16 June 2026

Burrendong Wind Farm SSD 8950984

I refer to your correspondence/email dated 27 May 2026 requesting advice with regard to the Amendment Report. Council Officers have reviewed the Amendment Report and provide the following comments:

Figure 2-5: Ancillary Infrastructure - Construction Compound and TWAF Area - Detailed

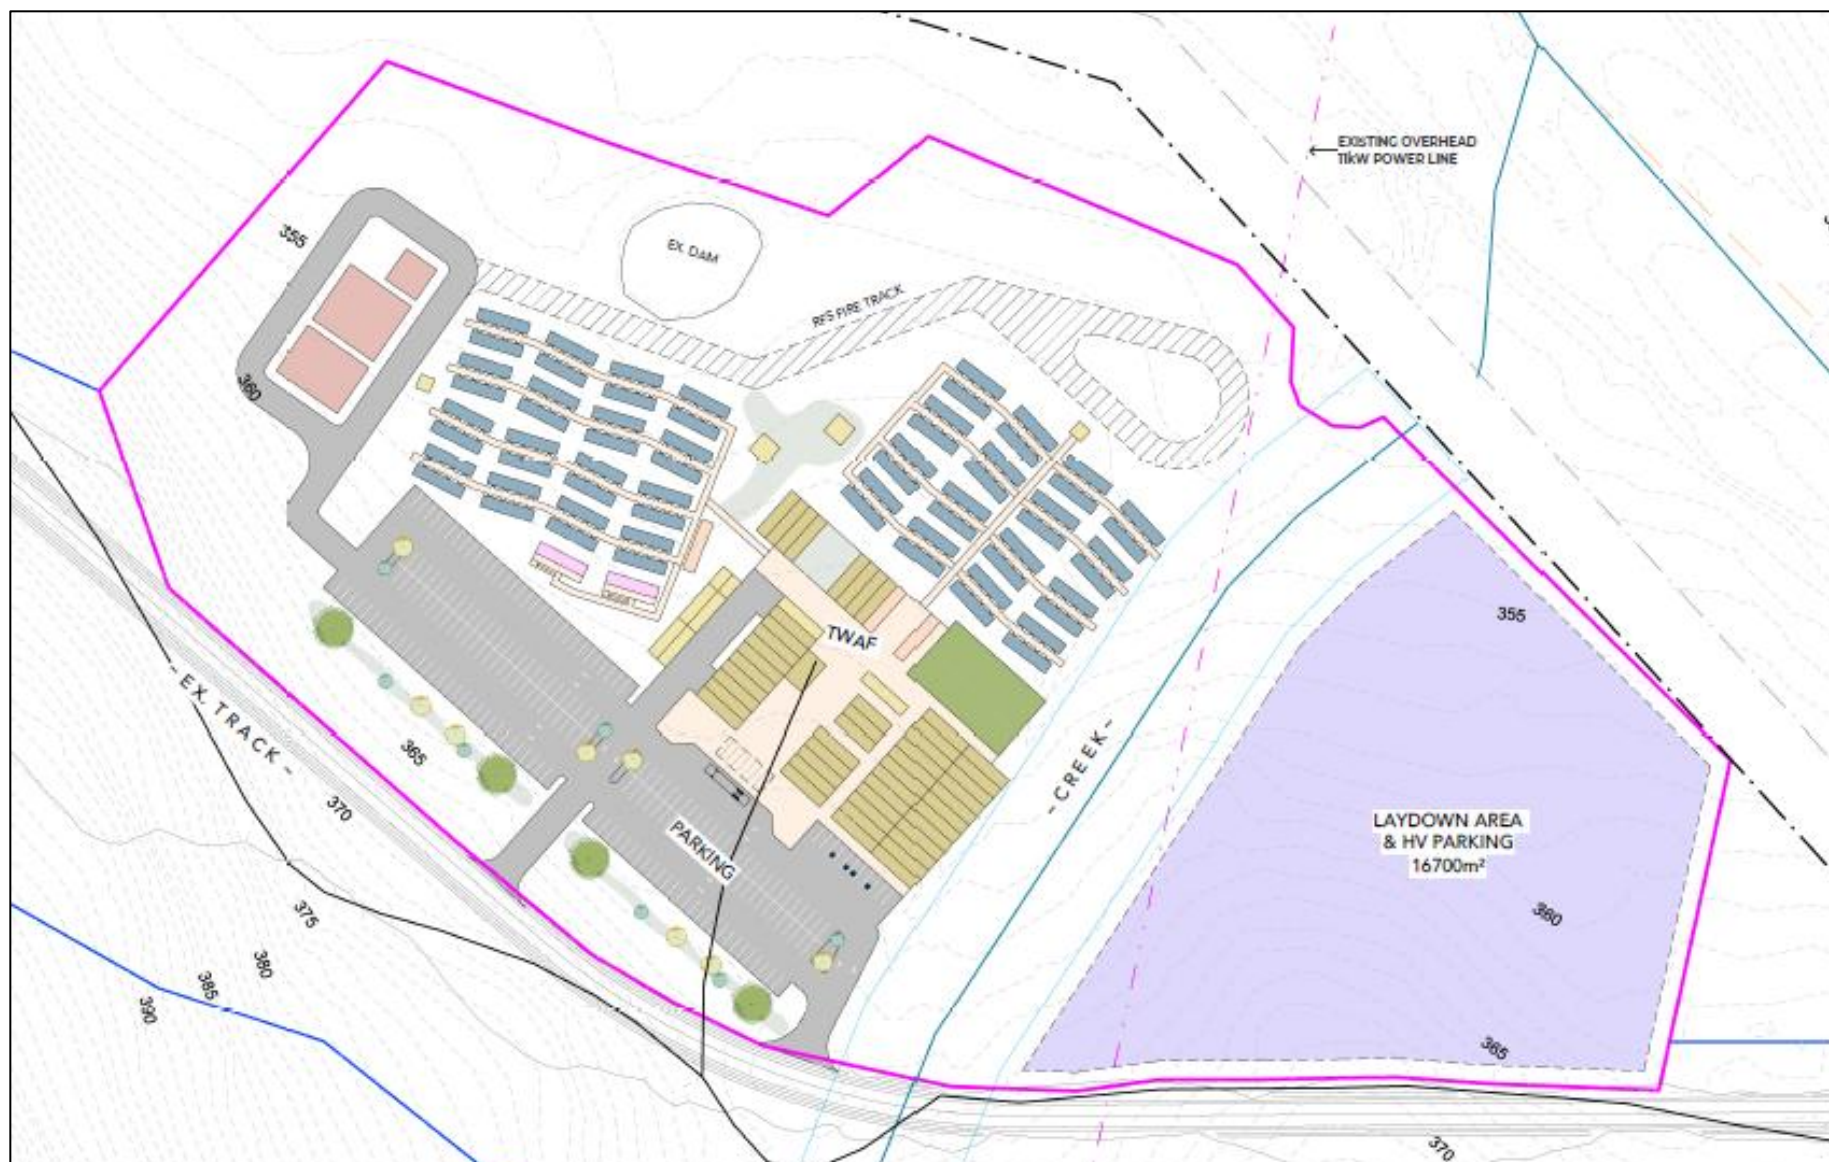
The proposed Temporary Workers Accommodation Facility (TWAF) has building regulatory implications as it will require section 68 approvals and construction certificates for its moveable dwellings and buildings; and a section 68 approval for its sewage treatment and effluent disposal.

The TWAF is identified as having 64 x 4 bed and 2 x 2 bed accommodation, thus comprising 260 residents. The amended report (Appendix A.2, page 21) identifies that-

There is concern with respect to the site potentially being unfavourable for onsite disposal due to the proximity to Burrendong Dam, due to the groundwater and the predominance of shale rock. Consequently, the development may have to store and pump-out sewage waste for transport back to Wellington for disposal at the Wellington sewerage treatment plant.

However, the provision of a Temporary Workers Accommodation Facility poses potential issues. Additional clearing of native vegetation, increased water consumption, isolated work camp waste disposal, sewerage treatment, cultural heritage management and bushfire planning.

- Waste management;
- Groundwater impacts;
- Sewerage disposal;
- Water supply to the facility;
- Bushfire Planning – evacuation planning is not addressed.

- Identify the approvals that are required to be obtained under the Local Government Act 1993 and Environmental Planning & Assessment Act 1979 for the proposed buildings and moveable dwellings that will comprise the Temporary Workers Accommodation Facility; and
- Identify the site constraints for the provision of onsite effluent disposal for the proposed Temporary Workers Accommodation Facility by undertaking a 'site and soil evaluation' as is required to be undertaken at development application stage pursuant to the NSW Governments Policy document 'Onsite Wastewater Management Guidelines' April 2025 (section 1.5 & Table 1-1).
